WEST SUSSEX COUNTY COUNCIL CONSULTATION

TO:	Arun District Council - FAO: Amber Willard
FROM:	WSCC – Highways Authority
DATE:	3 July 2026
LOCATION:	Sefter Farm Pagham Road Pagham PO21 3PX
SUBJECT:	P/76/26/PL Construction of a new engineering block building and car parking areas together with a new access road, footpaths and hard standing area. This application may affect the setting of a listed building and is in CIL Zone 5 (Zero Rated) as other development.
RECOMMENDATION:	More Information

NOTES:

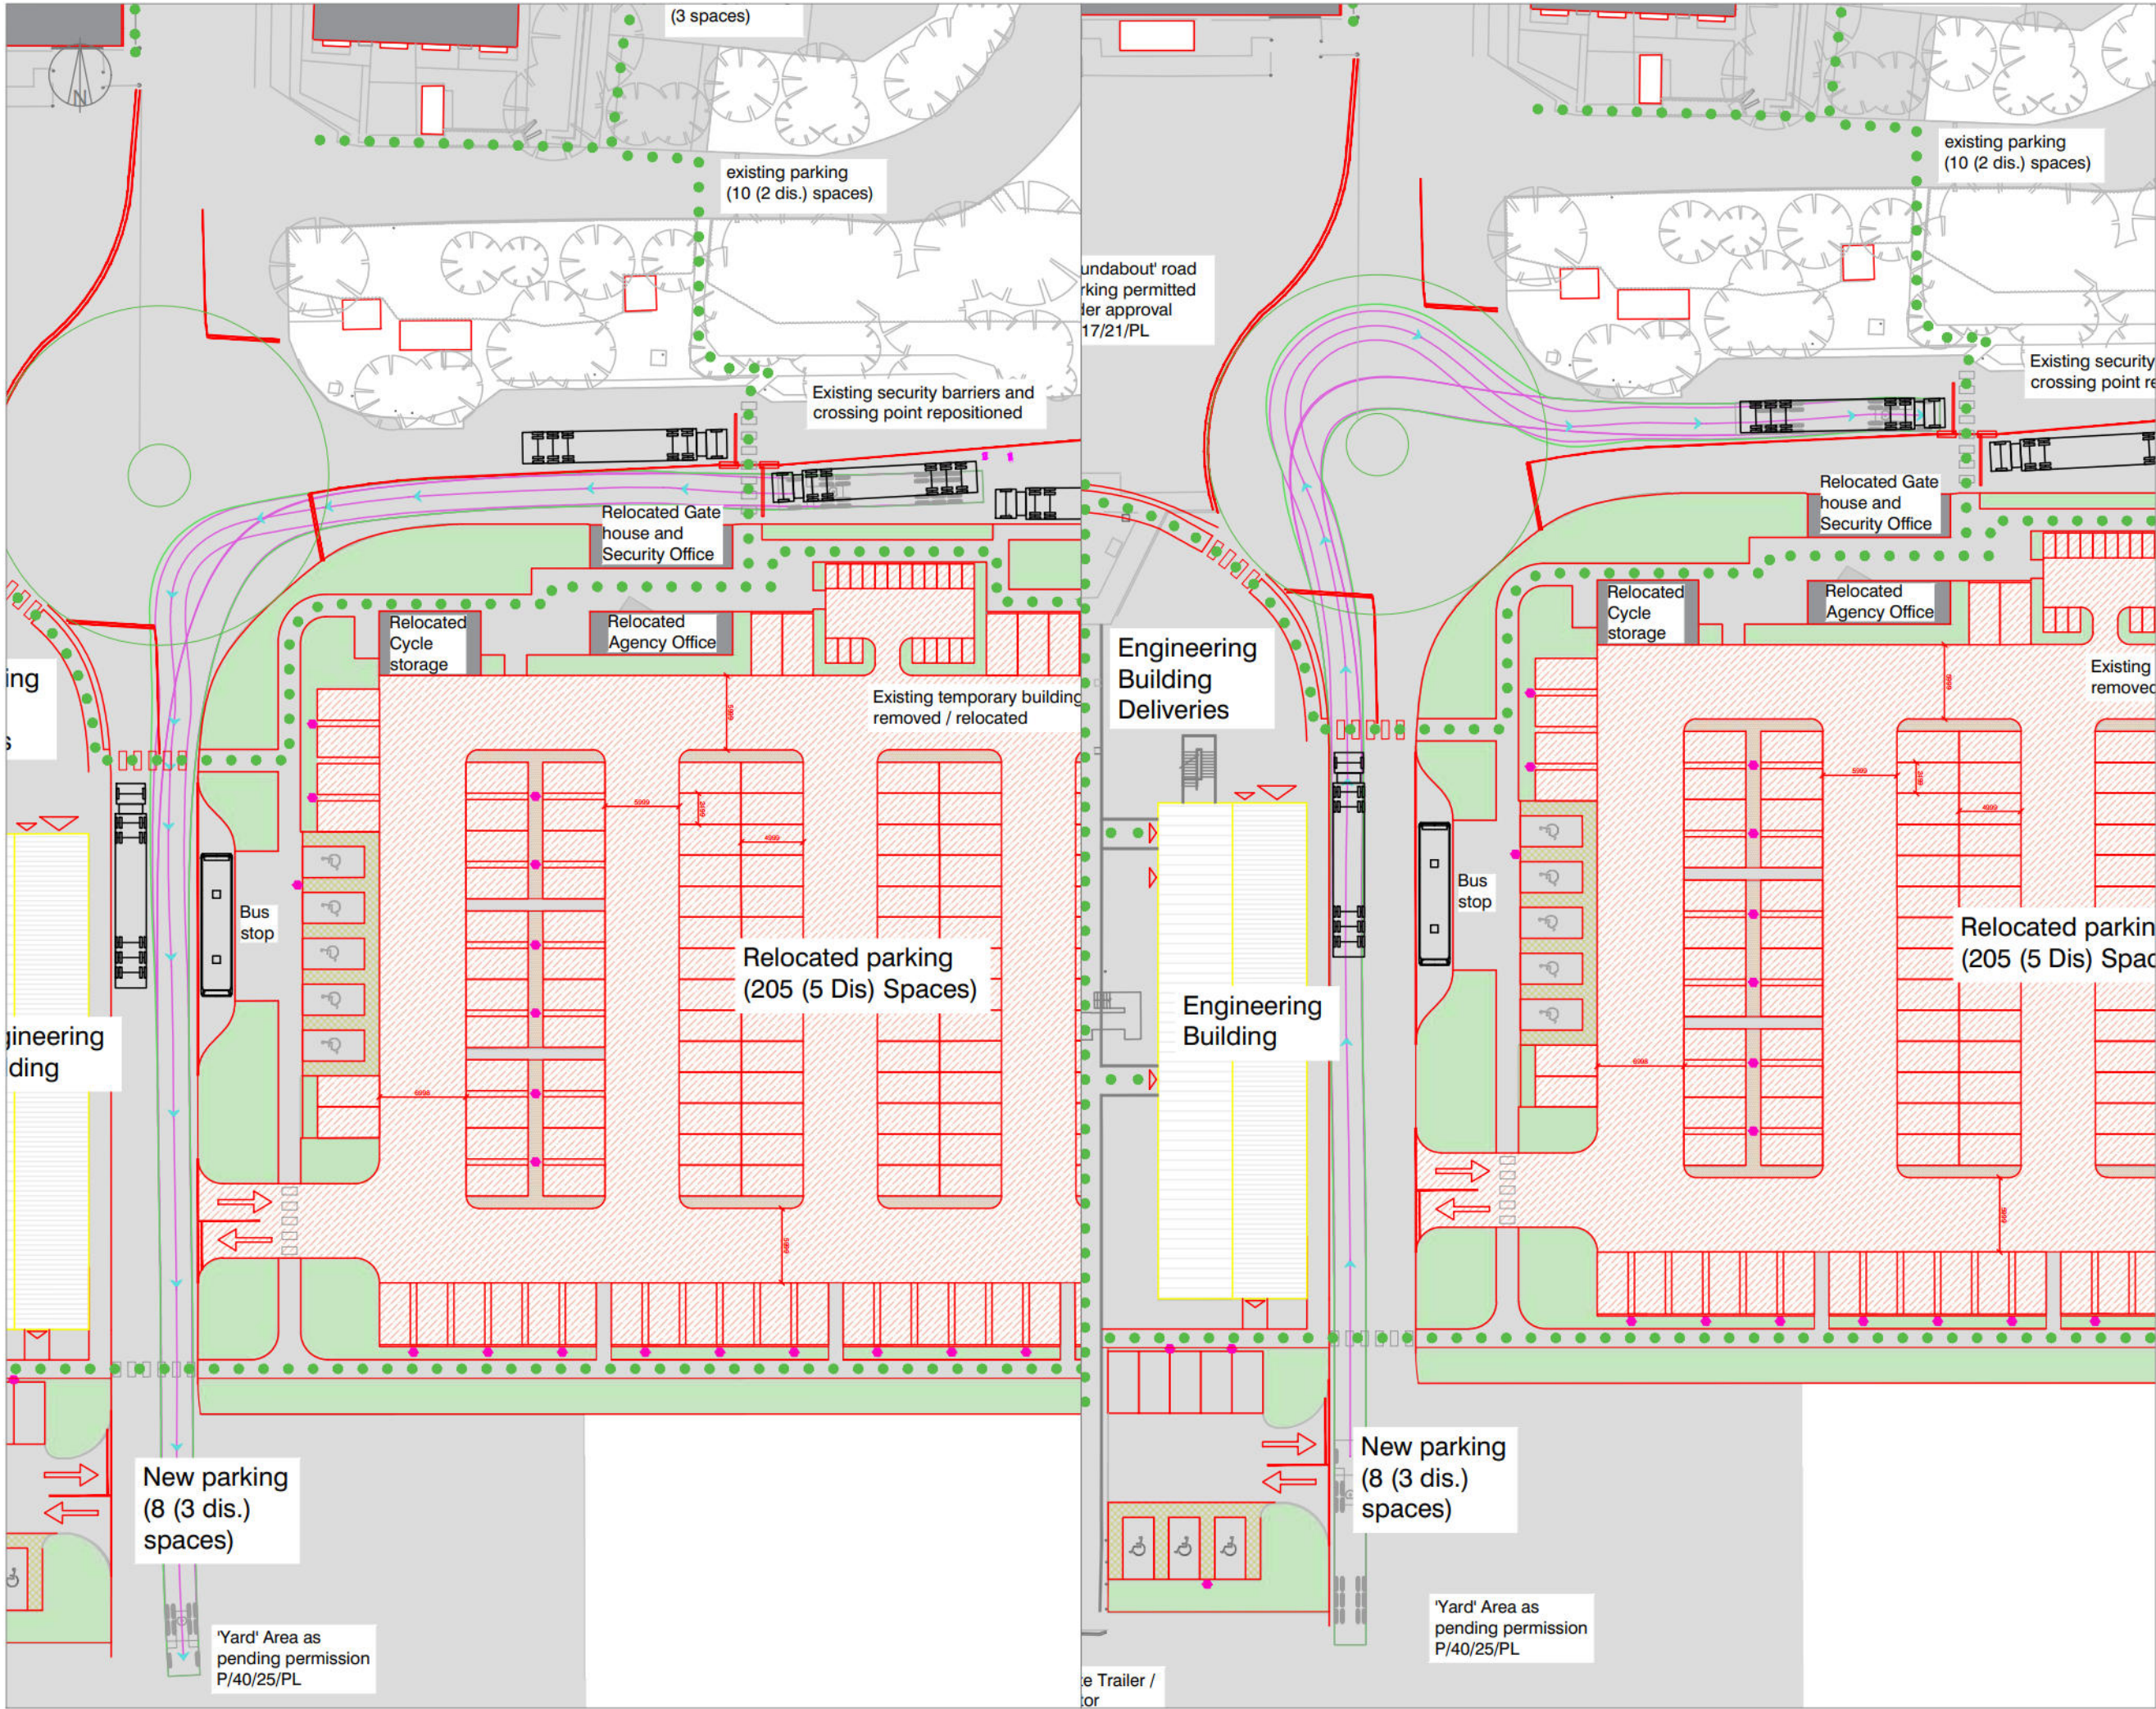
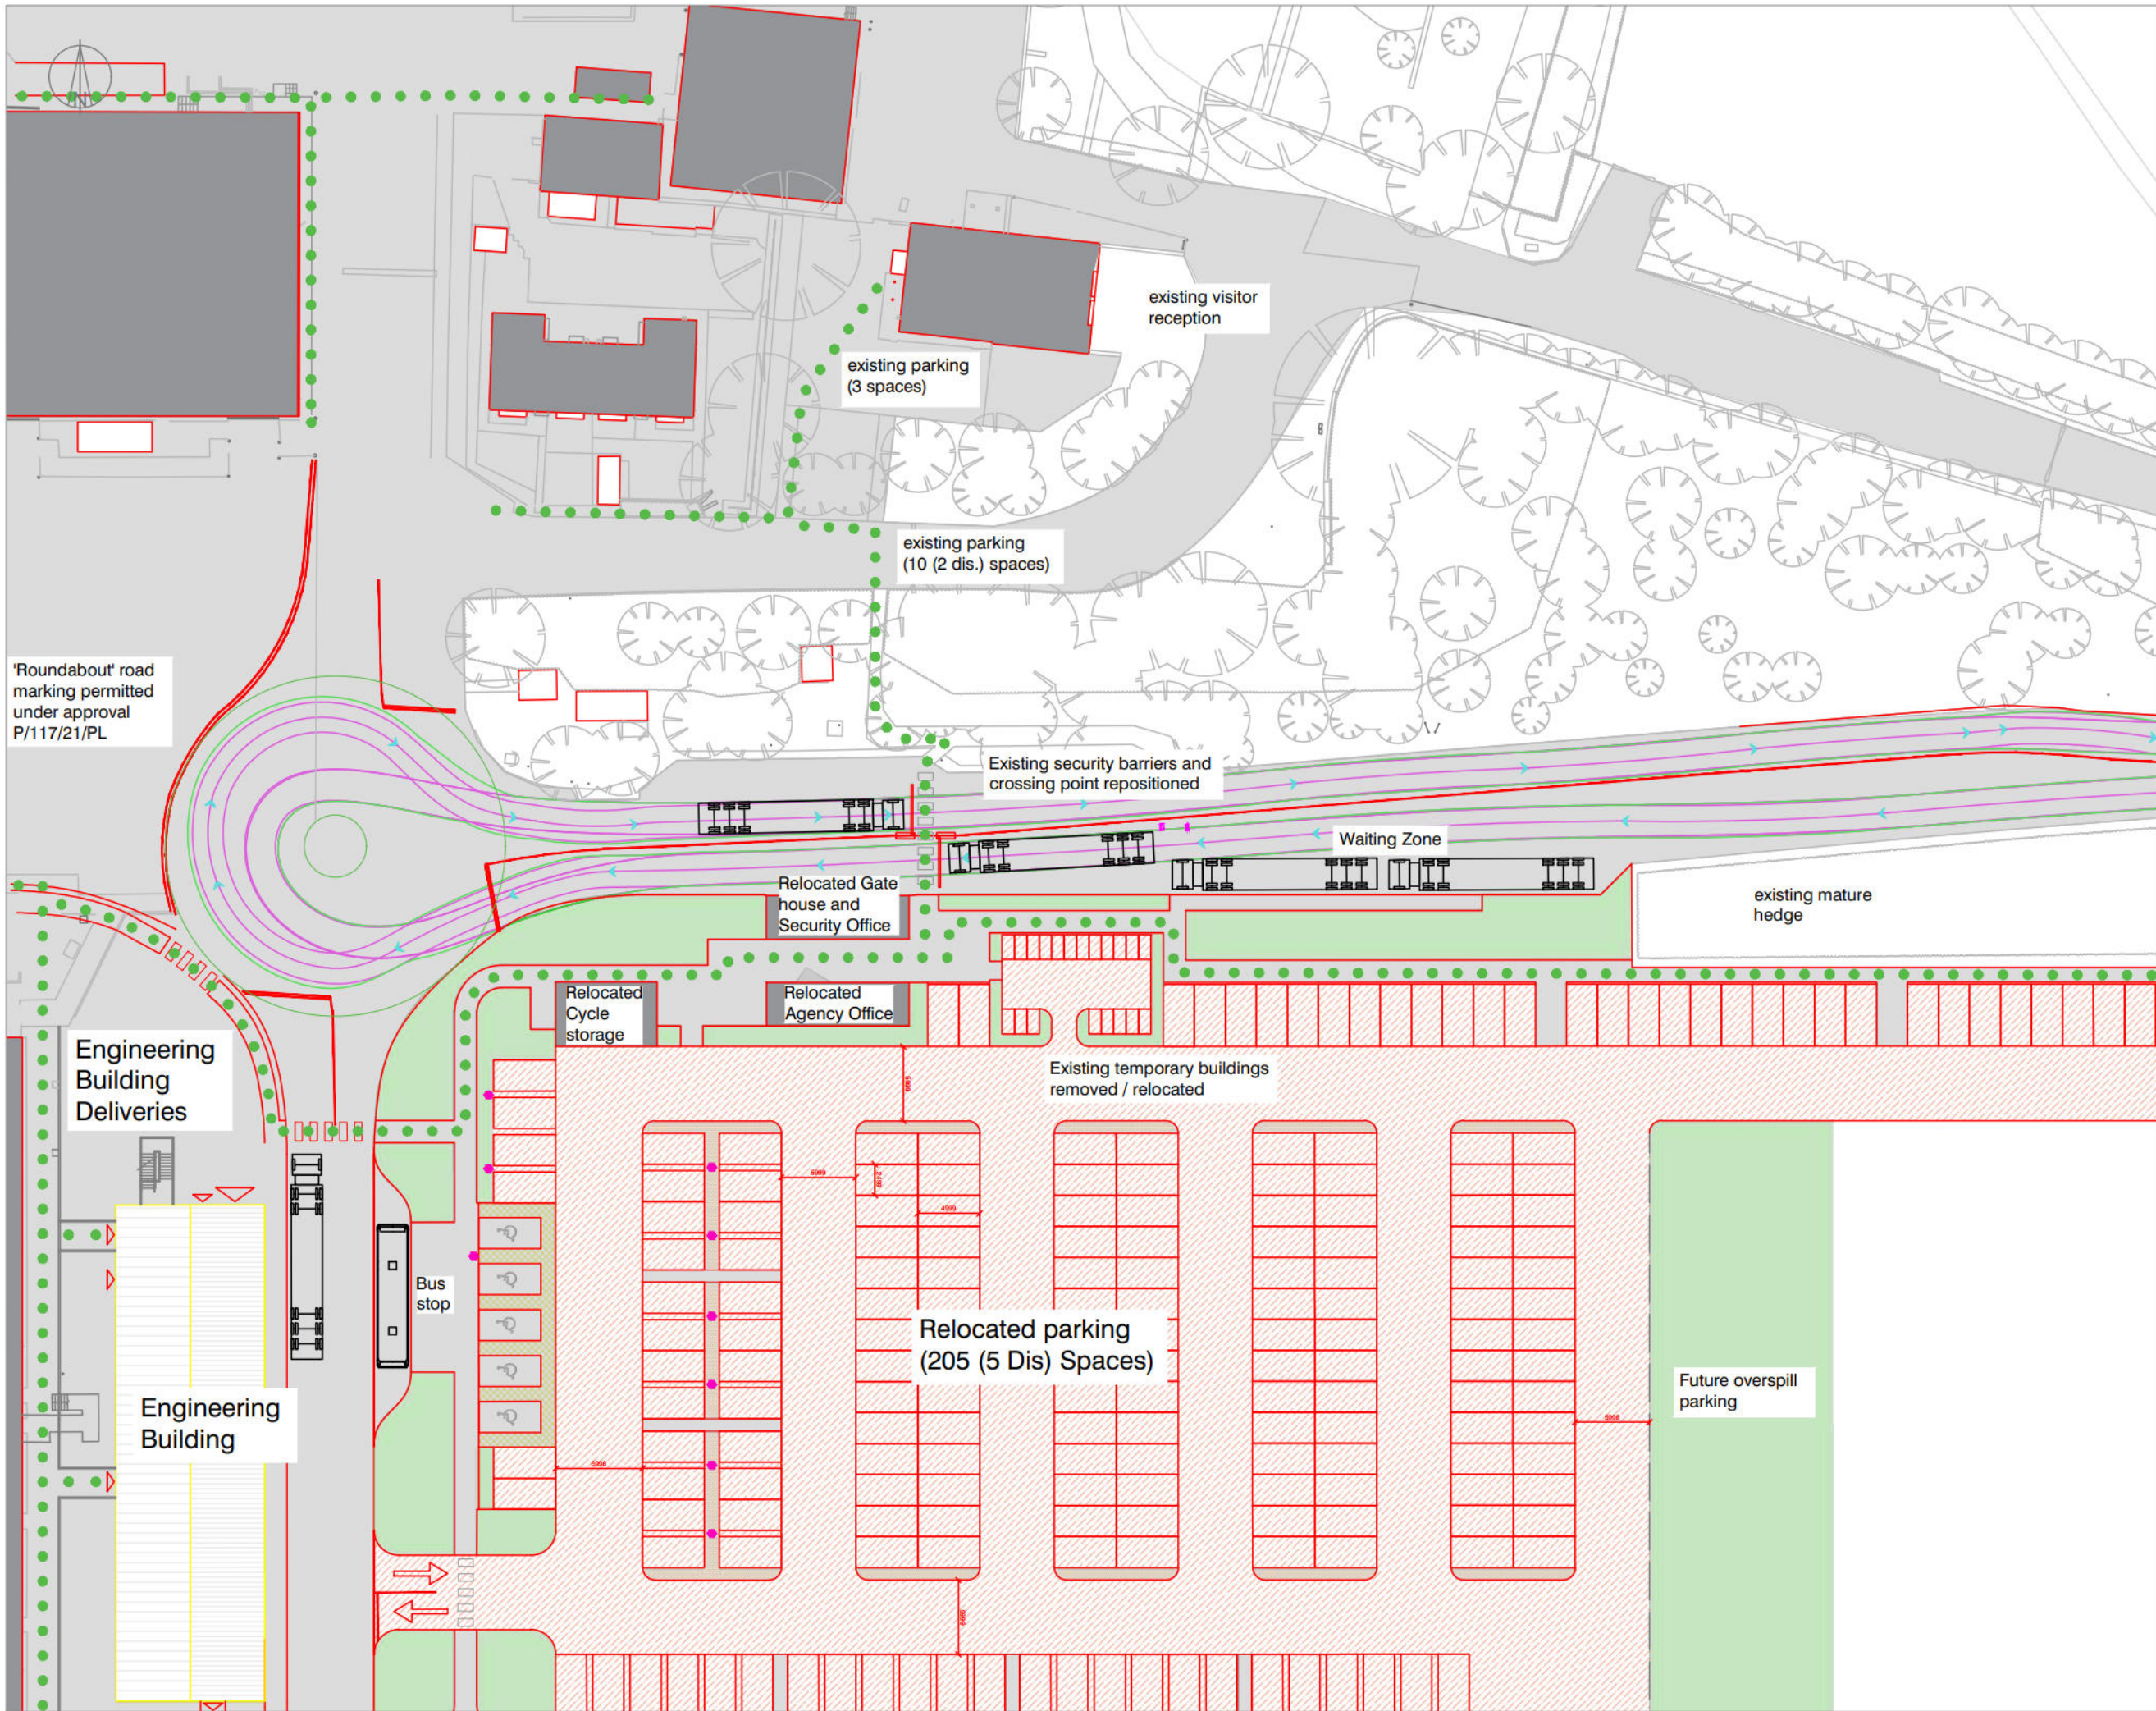
Whilst the site is rural and no cycle infrastructure on nearby roads exist, there is a bus stop to south at junction with Sefter Road with Chichester/Bognor service. However, Barfoots runs a bus service from within the site with services to Bognor/Littlehampton and Portsmouth for shift worker start/finish times. The internal bus stop will be relocated from along the main access road to west of the car park. It is advised that swept path tracking is provided to demonstrate workability including turning for bus.

- Updated TP.
- Swept path tracking for bus for new bus stop location, including turning on site.
